Application Ref:	3/2021/0539	 Ribble Valley Borough Council www.ribblevalley.gov.uk
Date Inspected:	07/06/2021	
Officer:	RB	
DELEGATED ITEM FILE REPORT:		APPROVAL

Development Description:	Conversion of garage to additional living accommodation with mezzanine level, single storey extension and Demolition of existing outbuilding to be replaced with new detached double garage. Resubmission of 3/2020/0770.
Site Address/Location:	Ravenswing Farm, Further Lane, Mellor BB2 7QB

GROUND FLOOR as proposed

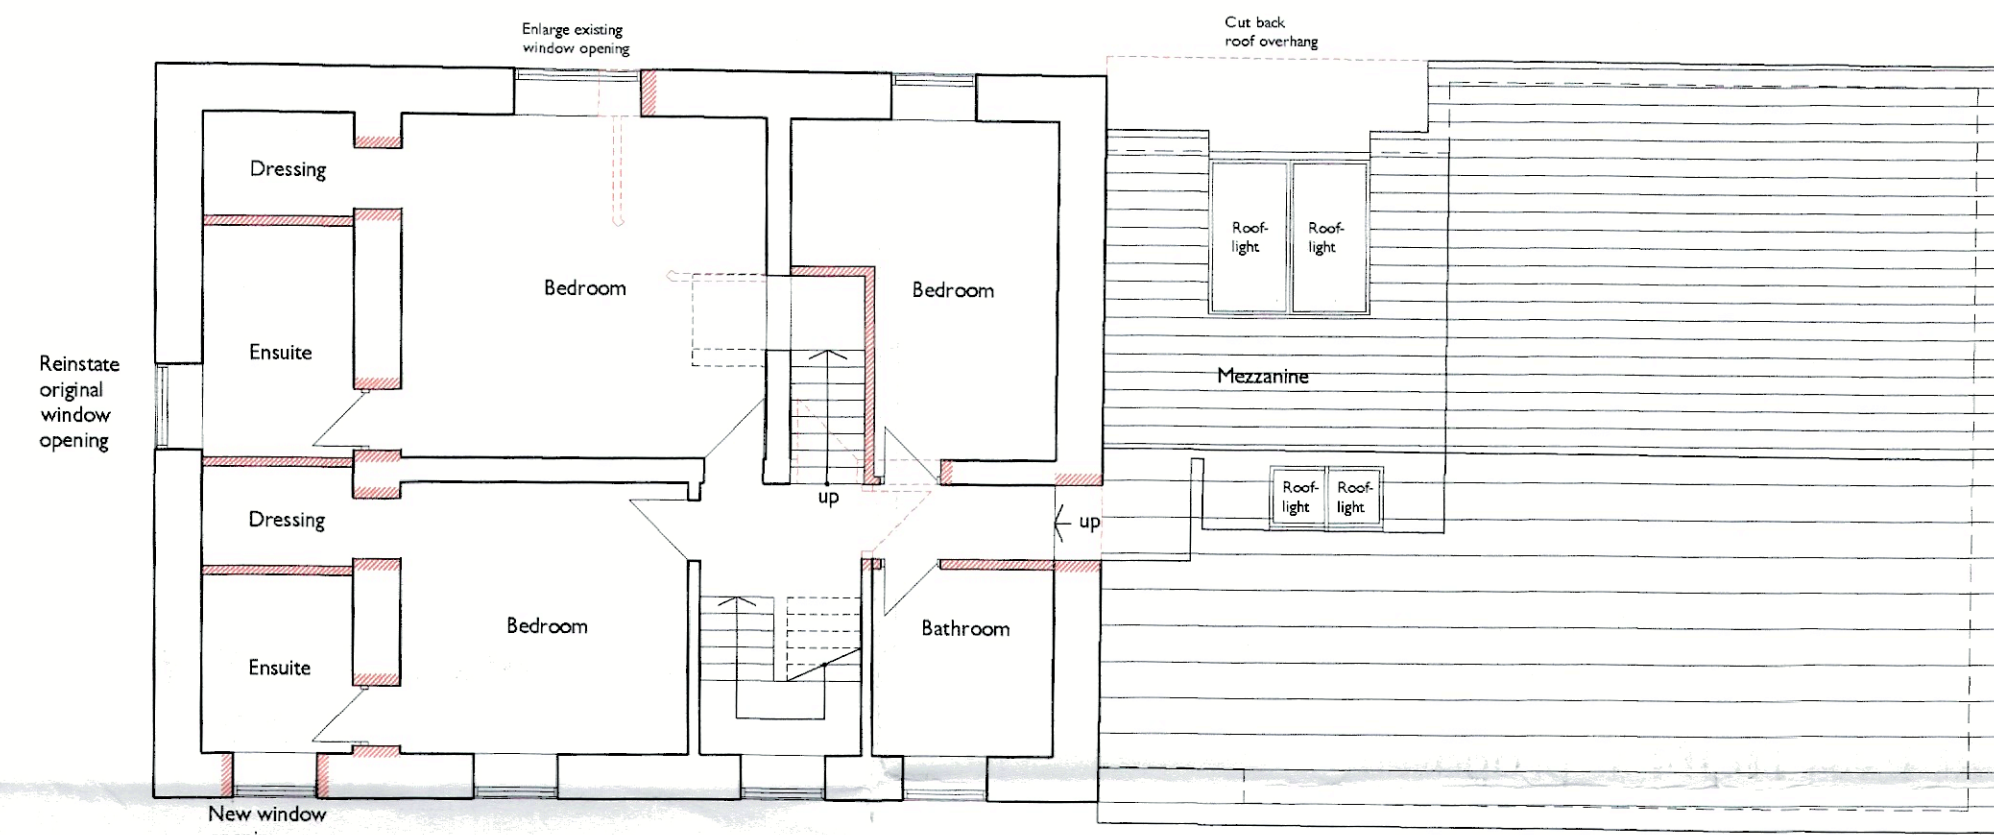
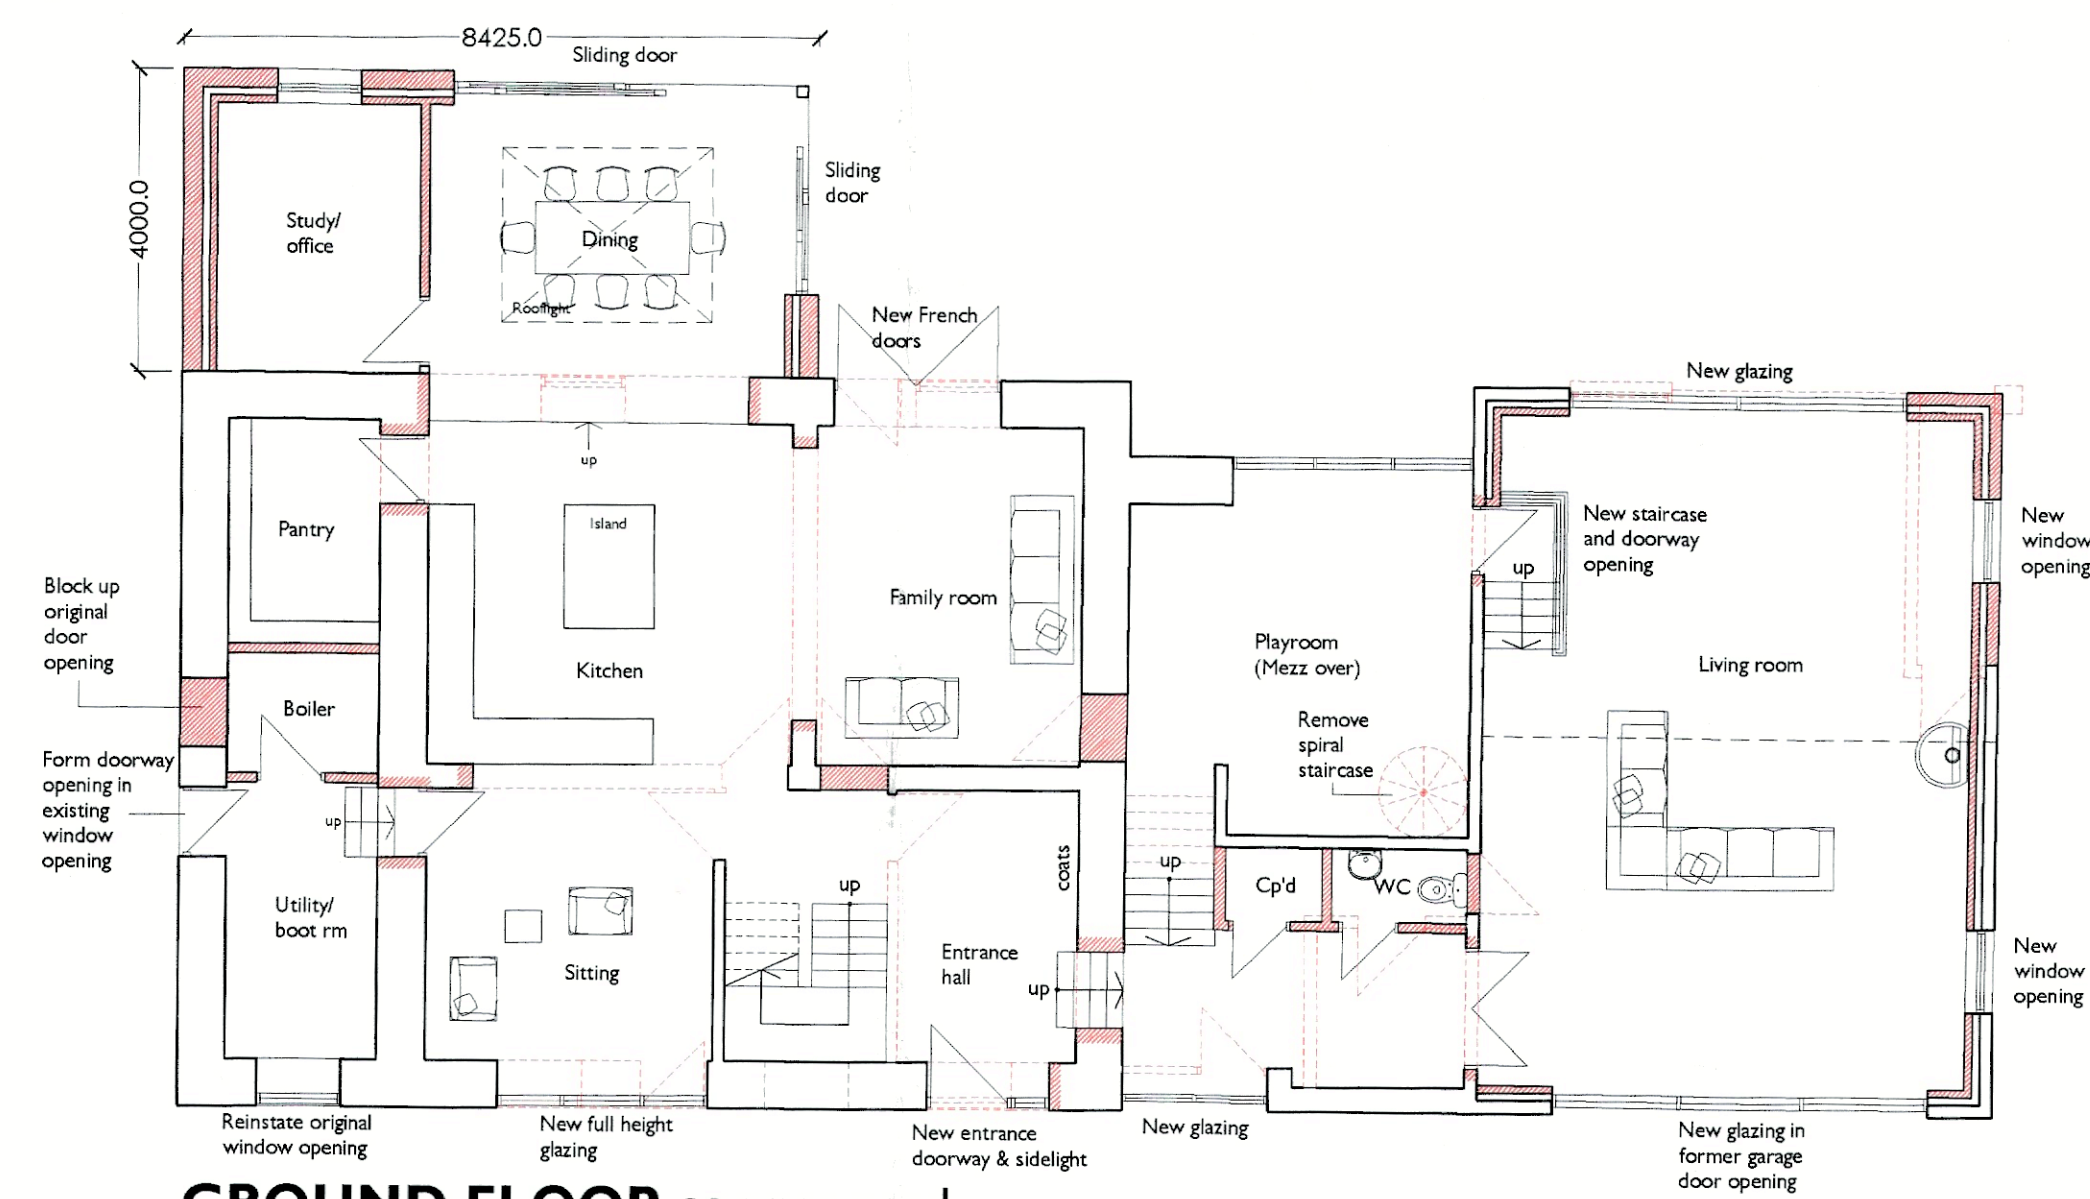
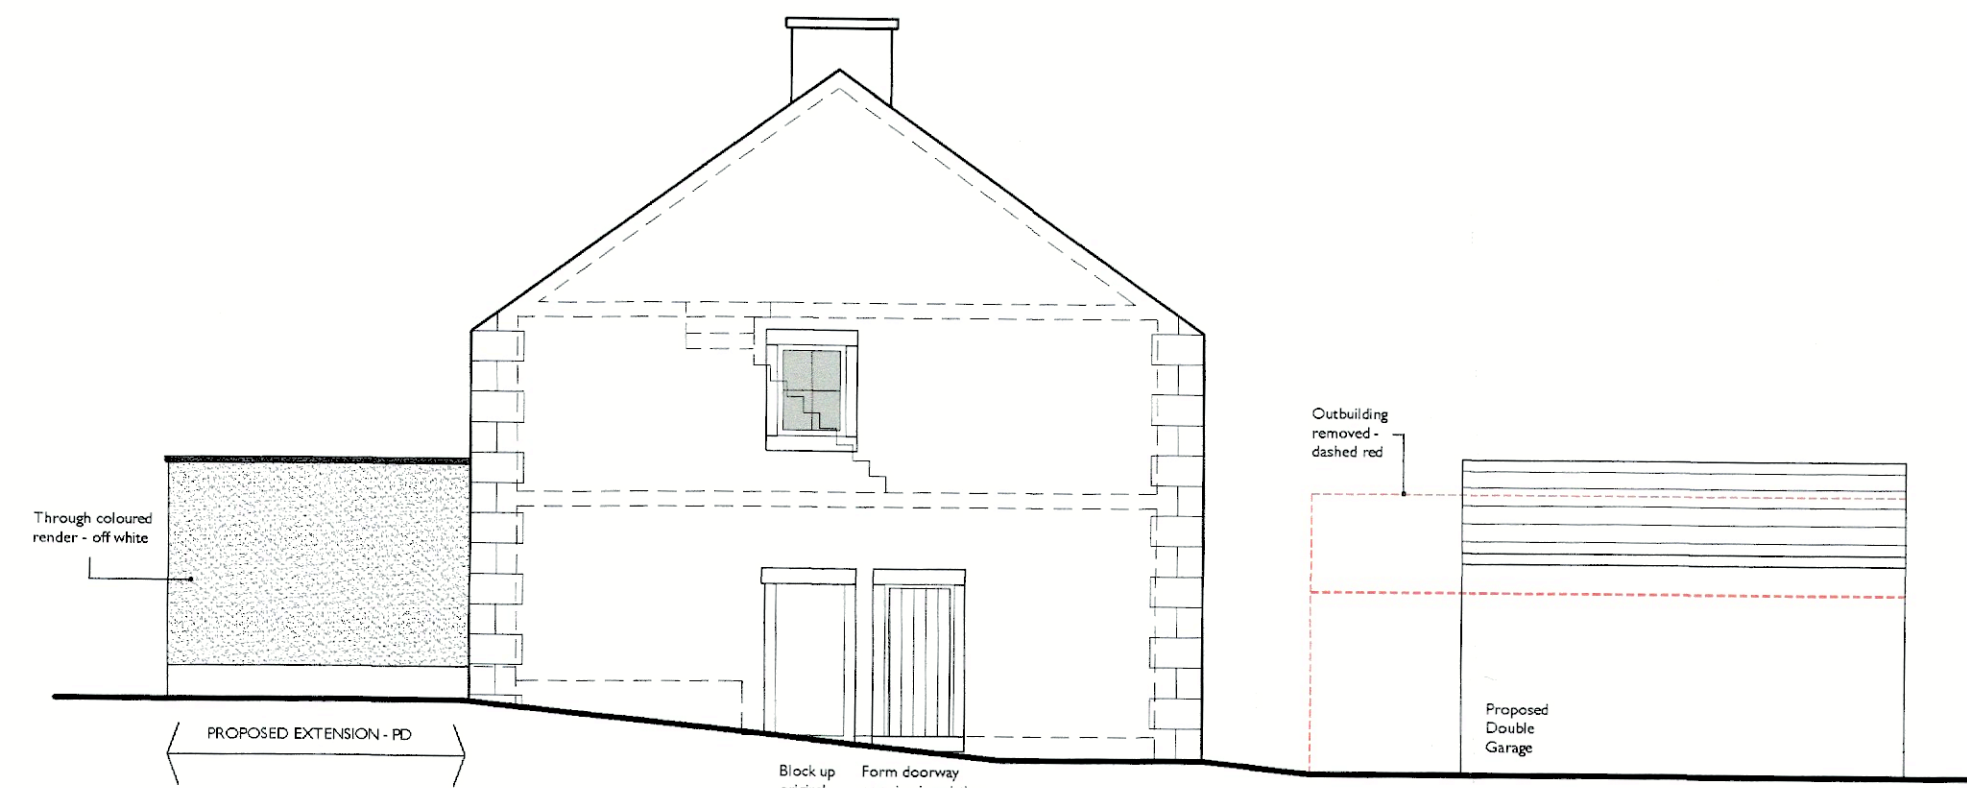
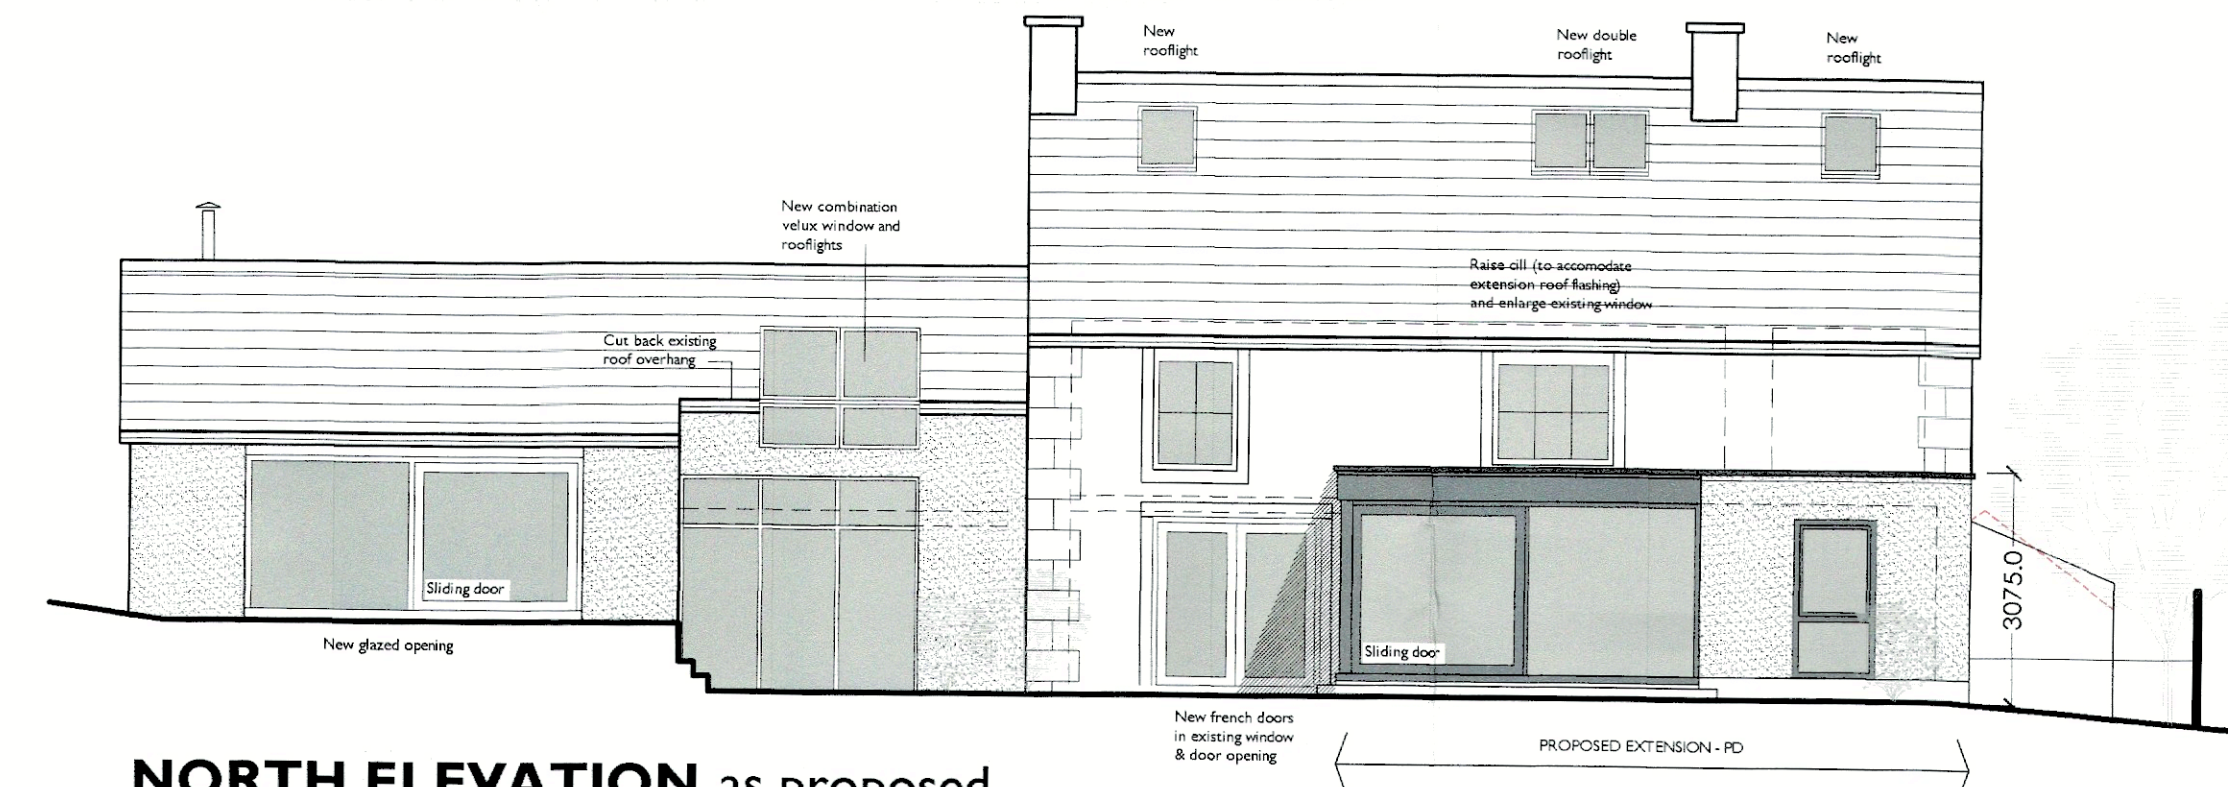
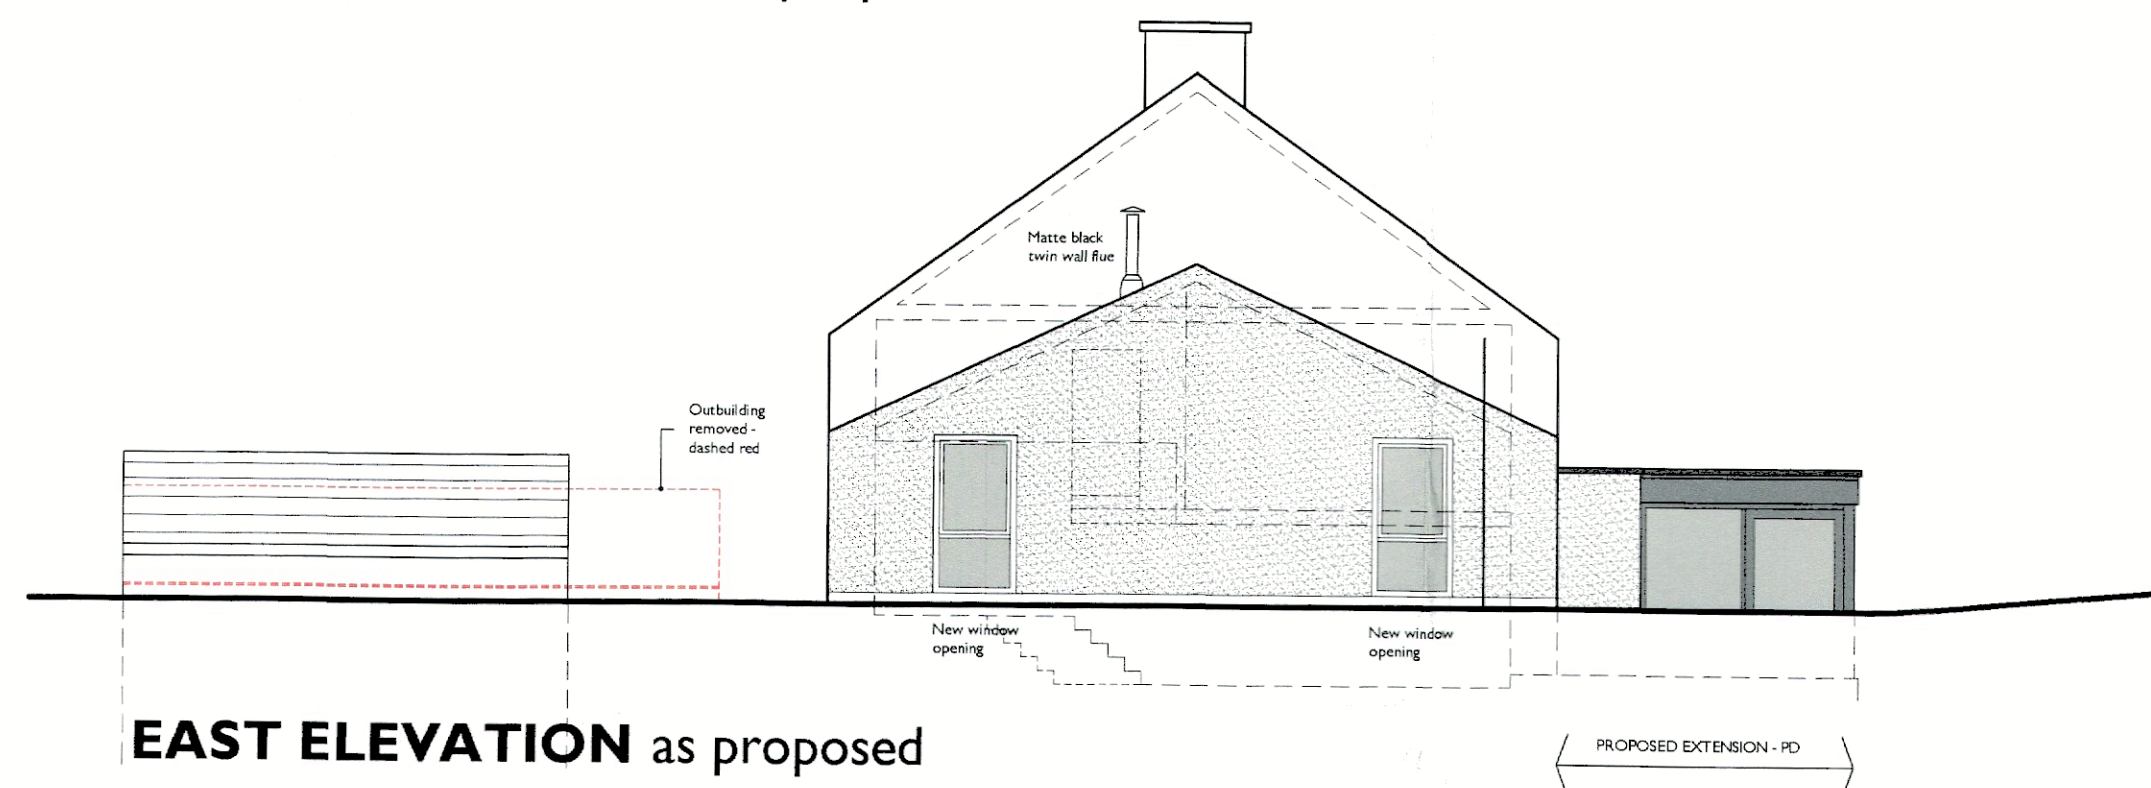
Conversion of existing attached garage extension to provide a living room and playroom with a mezzanine over the playroom. New glazing is proposed within the former garage door opening. New glazing is proposed across the rear and two new window openings are proposed to the east elevation.

Erection of a single storey extension to the rear of the main house that will have a rearward projection of 4m measuring 8.4m in width. The extension will have a flat roof measuring 3m in height.

The proposed single storey extension to the rear of the dwelling will be sited adjacent to two ground floor windows on the neighbouring property, Pipers Pool. The first is a small 'ventilation slit' style window that serves a non-habitable room and therefore loss of light to this window would not warrant refusal. The second window is a large glazed former barn door, that serves as an entrance hall to Pipers Pool. The proposed extension would result in some loss of light to this window however due to the size of the window and the fact that the window serves a non-habitable room it is not considered to warrant refusal of the application.

Due to the nature of the works to the attached garage relating to new window/door openings and these new openings not overlooking any neighbouring dwelling it is considered that these works are acceptable.

The works proposed to the conversion do not propose to any additional built form and therefore these works have negligible impact on the openness of the green belt. The proposed single storey extension to the rear of the dwelling would have some impact on the openness of the greenbelt. When this volume is calculated including the existing extensions the cumulative volume increase to the original is greater than the 30% allowance and would constitute disproportionate additions over and above the size of the original building. However, the property does still benefit from permitted development rights and this extension falls within the permitted development limitations allowed for detached dwellings. As such it would be unreasonable for the LPA to refuse consent for works that do not require planning permission.

The development proposes a number of alterations to the external appearance of the building including a number of sections of glazing to the front and rear elevation, two sets of sliding doors, glazing in place of garage door, and some new window openings. The dwelling will be faced with render as well as natural stone and the detached garage will be faced with render. The main elements of glazing relate to the rear of the dwelling on the least visible elevation. Compared with the previously refused application the new window openings to the front are sympathetic to the main building as the openings include a mix of windows identical in design to existing windows and the new glazed openings at ground floor have been significantly reduced in scale. As such it is considered that the proposed development would have an acceptable impact on the character of the application dwelling.
